From: Plant, Tom - Communities <Tom.Plant@Oxfordshire.gov.uk>
Sent: 05 January 2021 16:57
To: Bob Neville <Bob.Neville@cherwell-dc.gov.uk>
Cc: Transport CDC Minor <Transport.CDCMinor@Oxfordshire.gov.uk>; Planning <Planning@Cherwell-DC.gov.uk>;
Councillor Mark Cherry <mark.cherry@oxfordshire.gov.uk>
Subject: 20-03023-F-2 - 10 Reid Close Banbury OX16 0SZ

Planning application:	20/03023/F
Location:	10 Reid Close Banbury OX16 0SZ
Description:	Erection of a new 1 bed, two storey dwelling - It forms a side extension to the west of 10 Reid Close
Type:	Full Development
Case Officer:	Bob Neville

PROPOSED SITE PLAN

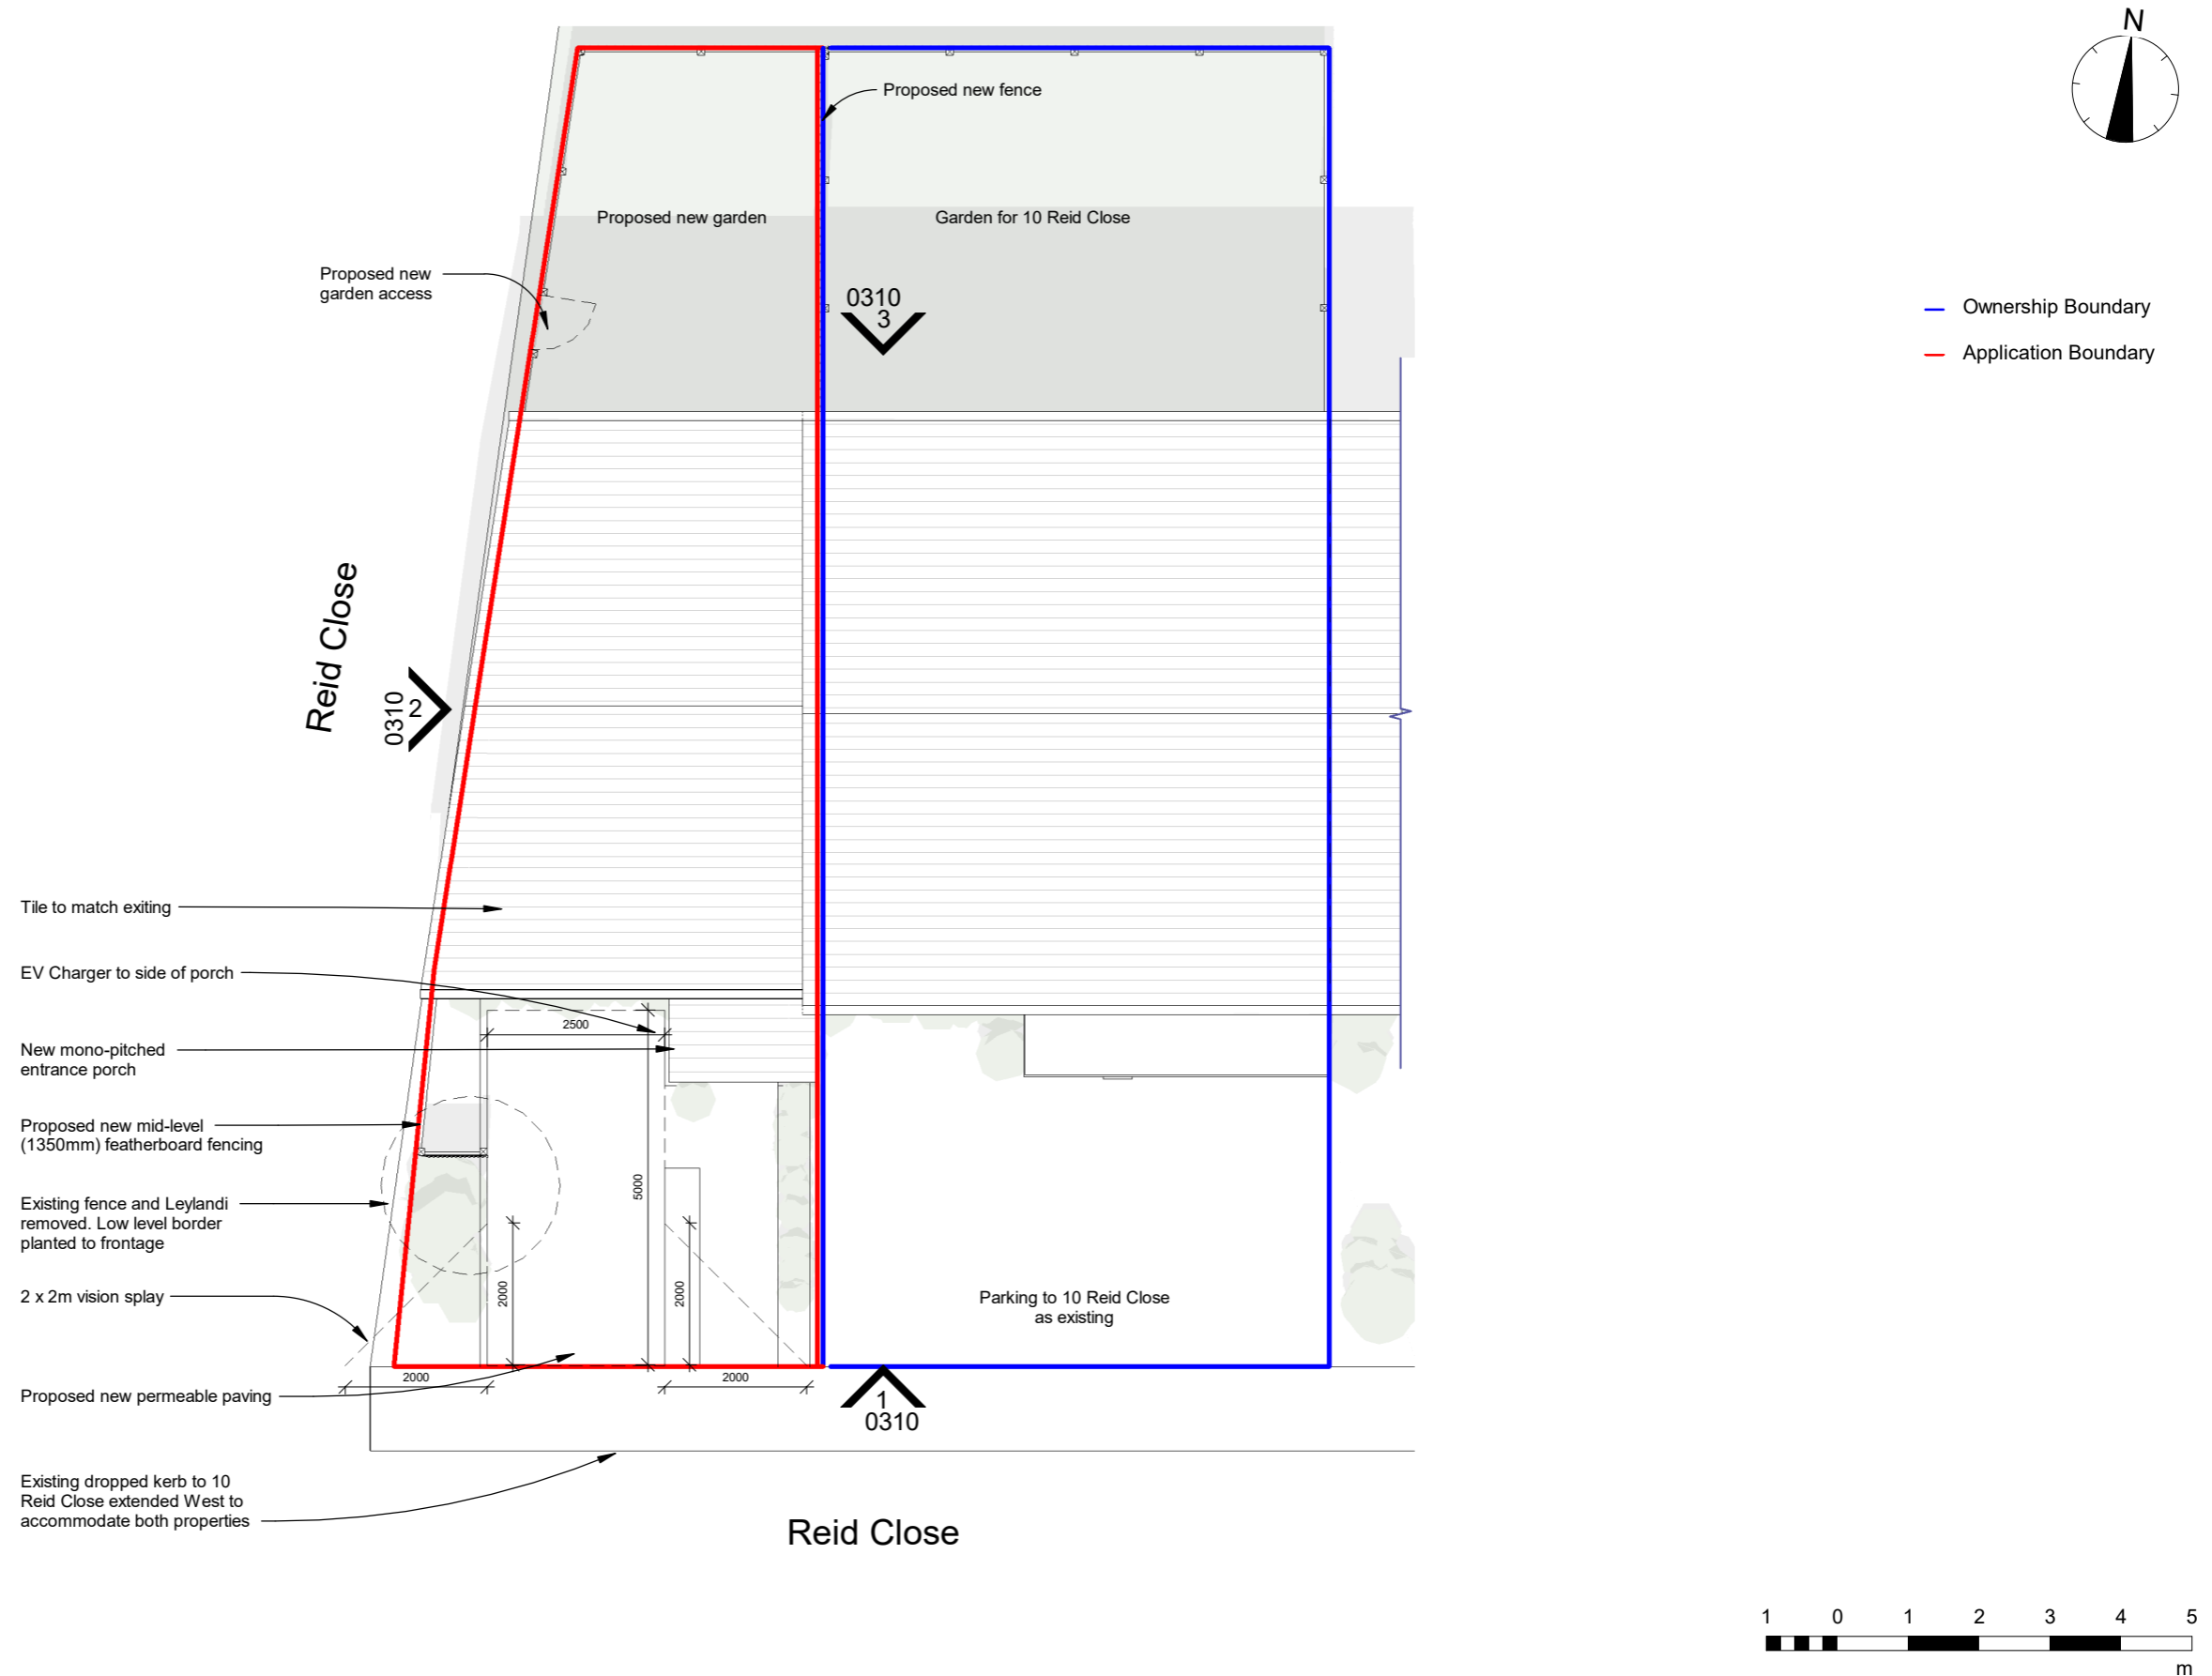
The adopted public highway doesn't extend to the frontage of the proposed dwelling (as of 9th December 2020 - public website can be viewed [here](#)), and terminates roughly in line with the former garage frontage of No 6 Reid Close. The redline will have to extend to the point of the

highway, and notice served on the third parties, prior to any application being permitted. Failure to provide adequate access to the public highway, will render any permitted dwelling at this location with no access to the highway, effectively rendering it marooned.

The Design and Access Statement makes reference to the provision of cycle parking on site. However, I have been unable to locate as to where this will be proposed on the submitted 'Proposed Site Layout Plan'. Therefore, a condition has been requested for details to be provided. The County Council recommends the use of Sheffield stands as the means of anchoring a bicycle, due to its universal design and dual function allowing other lawn related equipment to be secured to it.

Due to the close proximity of the proposed parking area to the existing garages, all means of enclosures, (including planting) must remain no greater than 0.6m in height to ensure that approaching pedestrians and vehicles will have adequate sightlines across the proposed sites front garden when egressing the garage area.

Prior to the first use/occupation of the development hereby approved, the parking and manoeuvring areas shall be provided in accordance with the plan approved (Drawing No. 1010 FCA XX 00 PL A 0110) and shall be constructed from porous materials or provision shall be made to direct run-off water from the hard surface to a permeable or porous area or surface within the curtilage of the site. Thereafter, the parking and manoeuvring areas shall be retained in accordance with this condition and shall be unobstructed except for the parking and manoeuvring of vehicles at all times. Reason - In the interests of highway safety and flood prevention and to comply with Policies ESD7 and ESD15 of the Cherwell Local Plan 2011-2031 Part 1 and Government guidance contained within the National Planning Policy Framework.

The dwelling hereby approved shall not be occupied until space has been laid out within the site in accordance with drawing no.1010 FCA XX 00 PL A 0110 P04 for bicycles to be parked and that space shall thereafter be kept available for the parking of bicycles. Reason: In the interests of promoting sustainable transport modes in accordance with Policy ESD1 of the Cherwell Local Plan 2011-2031 Part 1 and Government guidance contained within the National Planning Policy Framework.

The proposals, subject to the amendments received by the LPA 22nd December 2020 are unlikely to have an adverse impact upon the local highway network from a traffic and safety point of view, therefore I offer no objection, subject to conditions.
